From: [Arden Thomas](#)
To: [Melissa Munford](#)
Cc: [Kelly Bacon \(CD\)](#)
Subject: RE: ANDERSON_635033_currentheffectiveFIRM; ANDERSON_635033_PreliminaryFIRM_FutureReqCond
Date: Tuesday, February 18, 2020 11:17:31 AM
Attachments: [image001.png](#)
[image002.png](#)
[image003.png](#)
[image004.png](#)
[image005.png](#)
[image006.png](#)
[image007.png](#)
[image008.png](#)
[image009.png](#)
[53037C1256D.pdf](#)

Edward Anderson
7043 Manastash Road
Ellensburg, WA 98926

Subject: ANDERSON RESIDENCE - SITE PLAN UPDATE

SITE PLAN

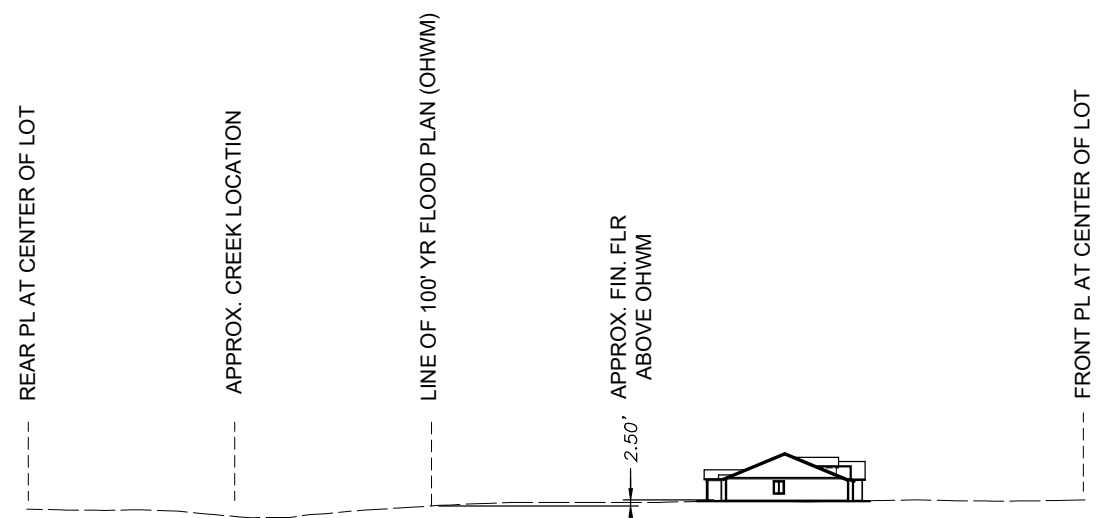
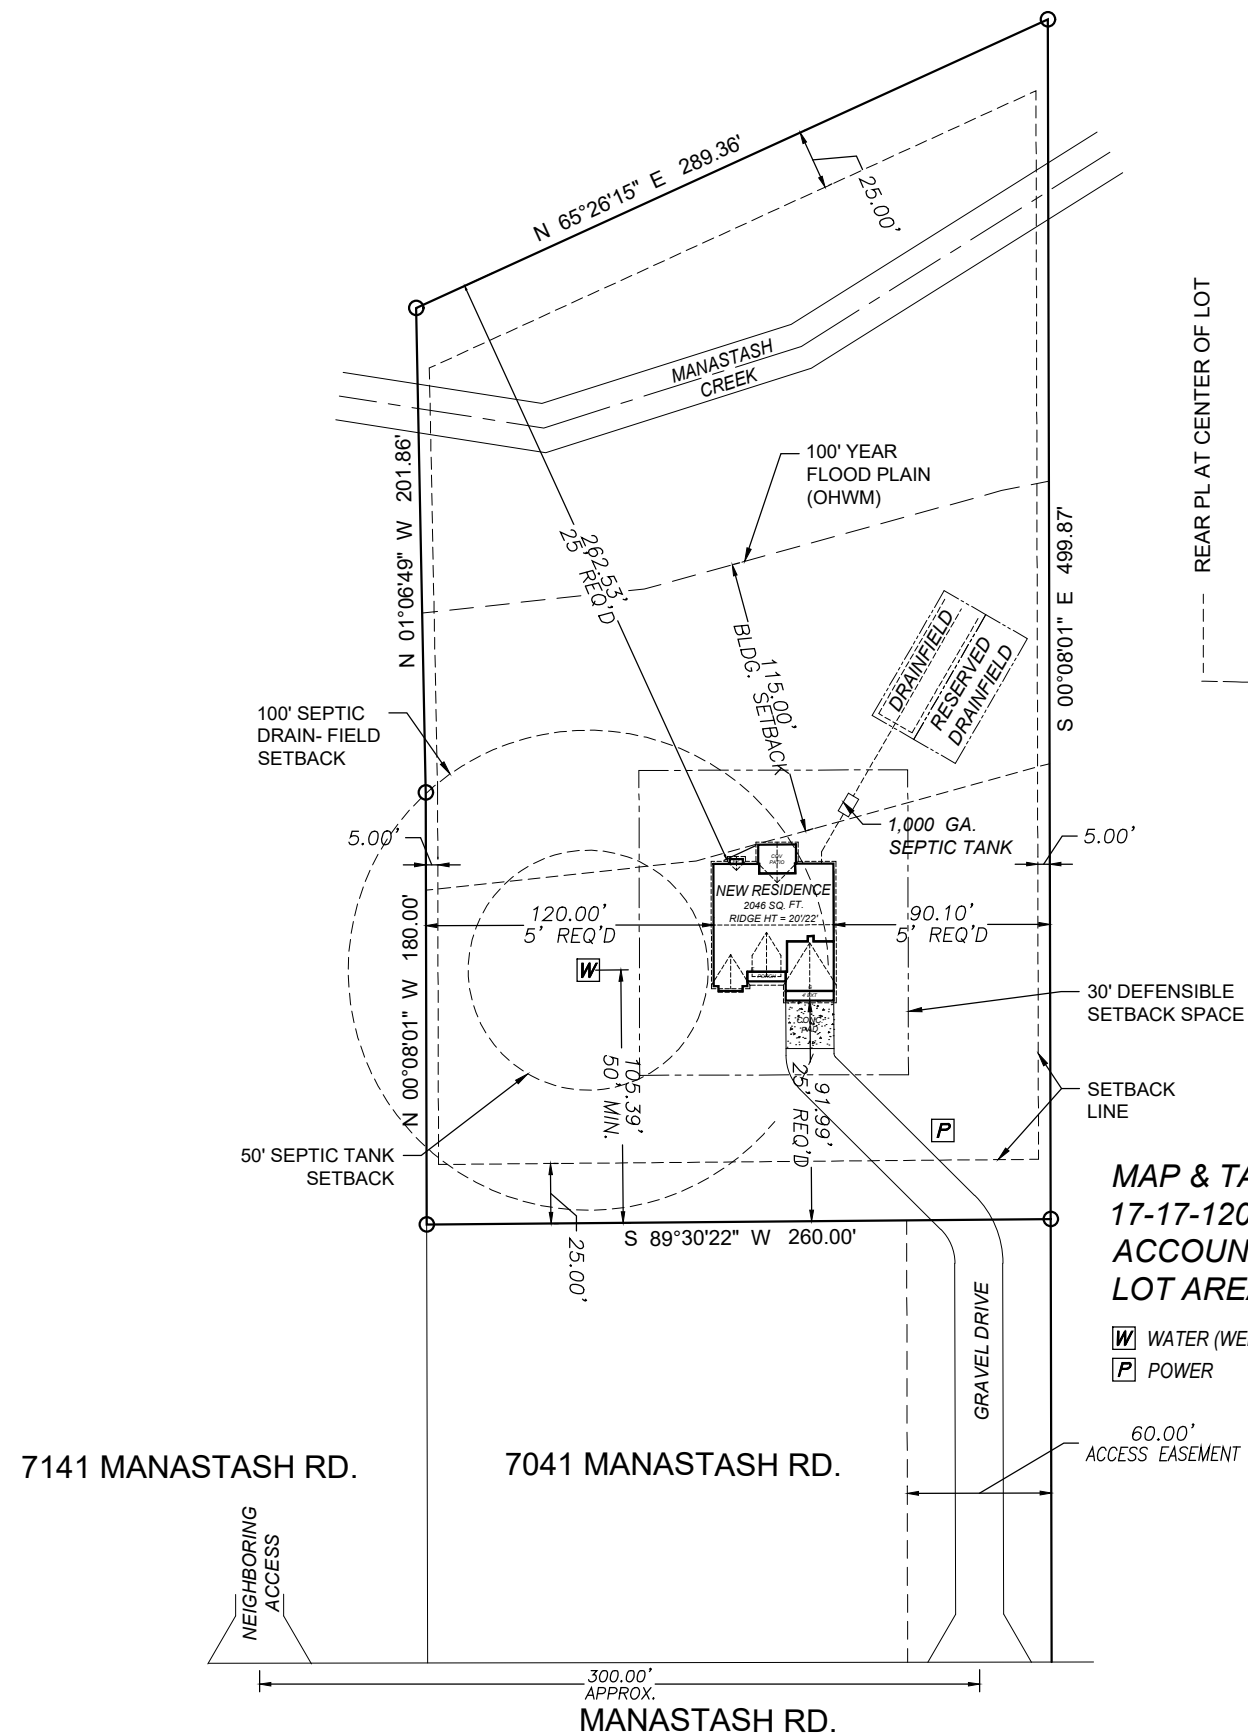
The site plan uses the [effective floodplain map](#), and the floodplain boundaries from this map should continue to be represented. A floodplain development permit is not required, because the building site is out of the 100-year floodplain, as shown on the effective maps.

That said, we also know that FEMA is very close to adopting new maps (these new maps are the preliminary maps provide by FEMA on 3/26/18). I recommend that the landowner takes these preliminary maps into account, in order to reduce flood risk to the structure and also make sure that the home will continue to be compliant with the floodplain development regulations when the new maps become effective (which can have implications both for flood insurance and also future permitting considerations). I've attached the preliminary map for that location.

Given these new maps, I've requested (via an email that was sent to Kelly Bacon last week), an in-person meeting with the applicant to discuss the site plan and flooding risks. If we need to set up remote conferencing to facilitate participation by the design team, we can do that. The bottom line is that I recommend that a surveyor establish the lowest adjacent grade for the current building site, and if this elevation is below 1968 feet NAVD 88, the site either be elevated through fill to obtain this grade, or that the house be elevated through other methods.
